REQUEST	Current Zoning: UMUD-O, uptown mixed-use district, optional Proposed Zoning: UMUD-O S.P.A., uptown mixed-use district, optional, site plan amendment.
LOCATION	Approximately 7.68 acres located in the block bounded by E. Trade Street, N. Caldwell Street, E. 5th Street and the Lynx Blue Line.
CENTER, CORRIDOR OR WEDGE	Center
SUMMARY OF PETITION	This request seeks a site plan amendment to an existing UMUD-O for the City of Charlotte Arena to allow the option to add signage.
STAFF RECOMMENDATION	The request is consistent with the adopted plans for the area. However, staff does not support some of the signage or banners that advertise Time Warner Services or the option to use reflective paint, digital signage or LED color changing lights on the rooftop sign. These specific signs are outlined in the outstanding issues. Staff recommends approval upon resolution of outstanding site plan amendment issues.

PLANNING STAFF REVIEW

sheet 2.5p

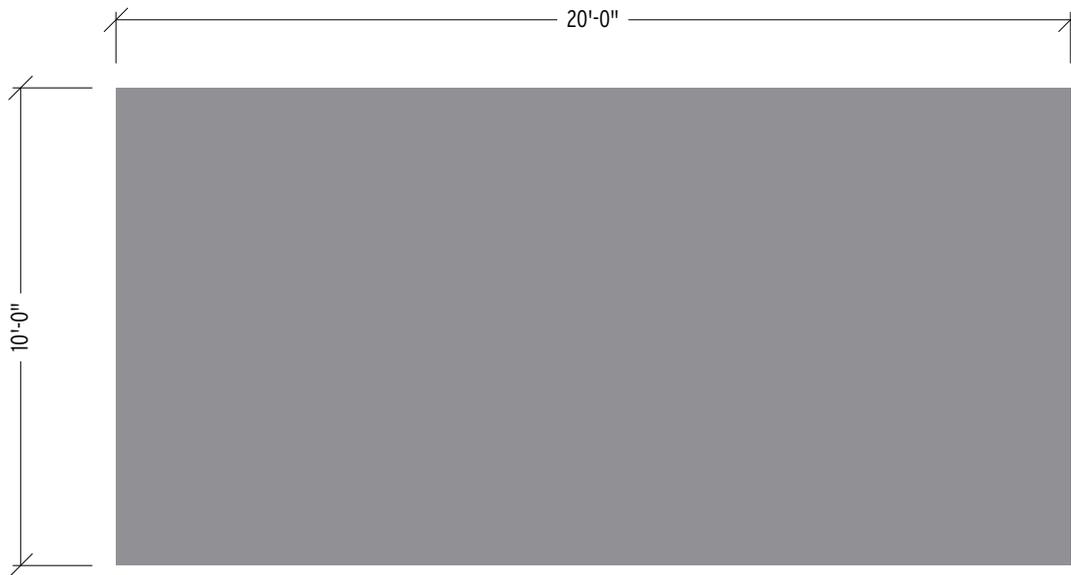
- A new wall sign (sheet 2.5p(a1)(a2)) along the façade facing East Trade Street and North Caldwell Street with the Time Warner Cable Name and three hexagonal logos that will be 612 square feet.

1. The petitioner should eliminate the hexagonal accent pieces, which are advertisements, from all signs except the sign shown on sheet 2.9p which is located next to other advertisements.
 2. The petitioner should eliminate the replacement banners with hexagonal accent pieces and the Roadrunner character, which are advertisements, from the package.
 3. The petitioner should eliminate the options to use reflective paint or digital signage and LED color changing lights on the roof sign. These options could allow this sign to be intrusive to people in the surrounding high rise buildings.
-

sheet 2.6p

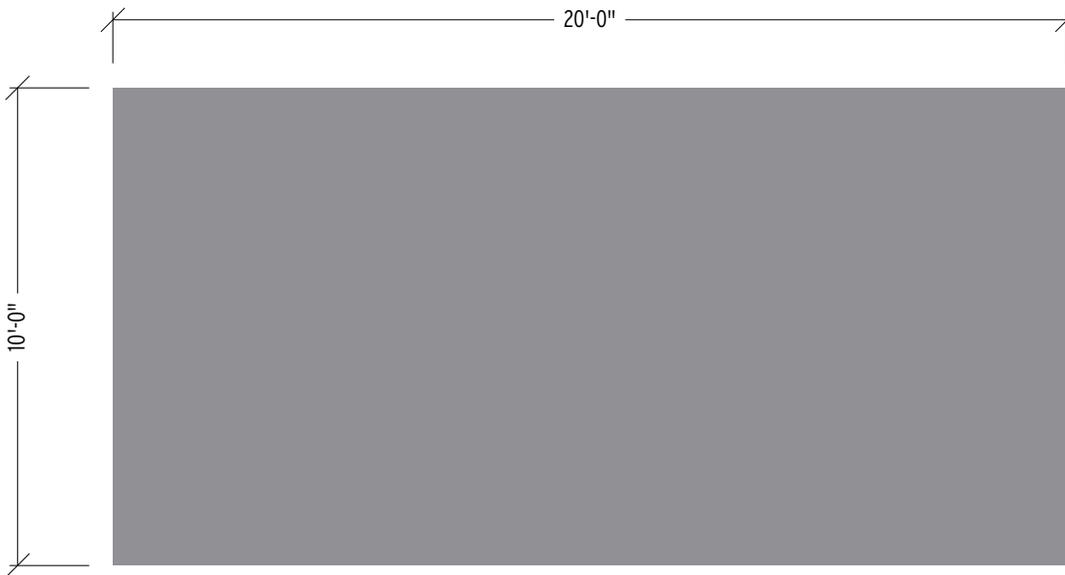
- A new sign (sheet 2.6p) above the North Caldwell Street entrance with the Time Warner Cable name and three hexagonal logos that will be 212.5 square feet.

sheet **2.7p**

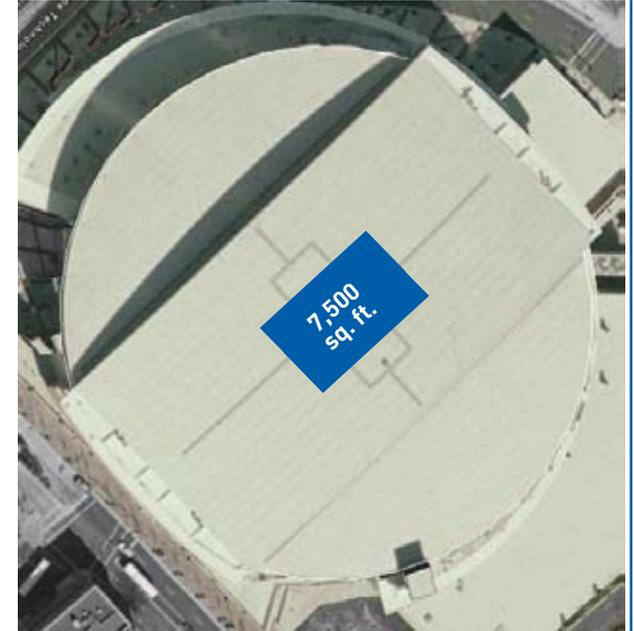
- A new rooftop sign (sheet 2.7) on the arena roof with the Time Warner Cable name that could be reflective paint, digital signage or LED color changing lights that will be 36,250 square feet.

The use of reflective paint or digital signage and LED color changing lights on the roof sign would cause visual clutter and light emissions that may be intrusive, especially to residents in high rise buildings.

[2.8p] Paegentry Banners

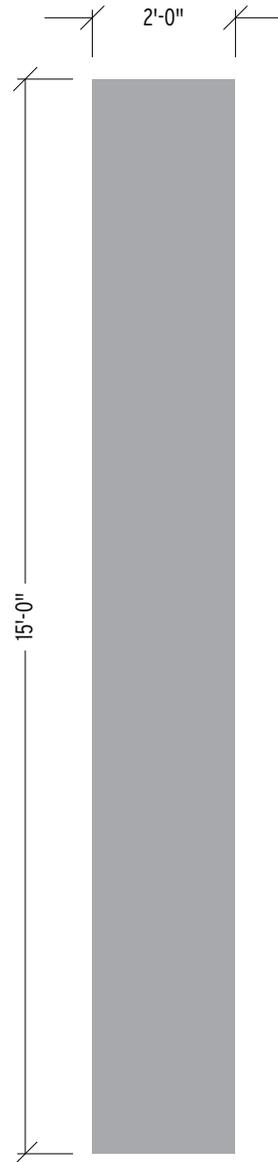
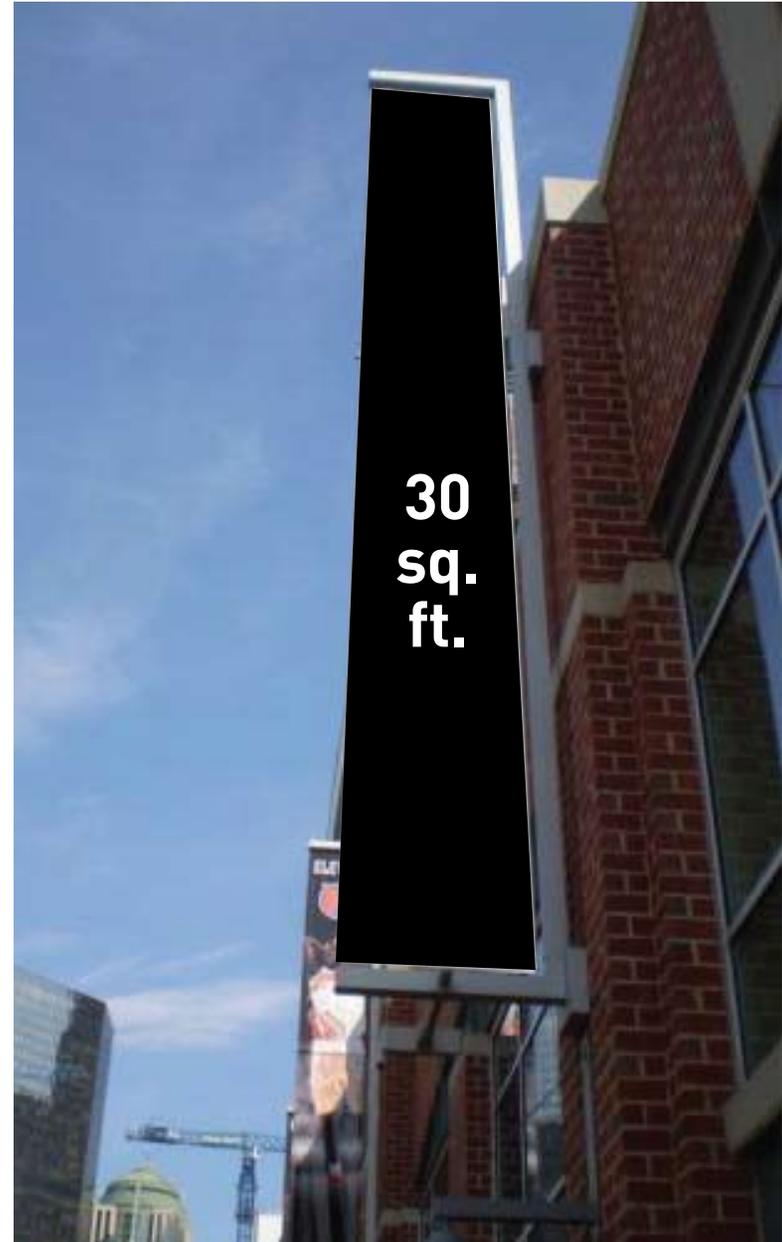
- Two replacement banners (sheet 2.8p) along East Fifth Street with the Time Warner Cable name and three hexagonal logos that will be a total of 72 square feet.
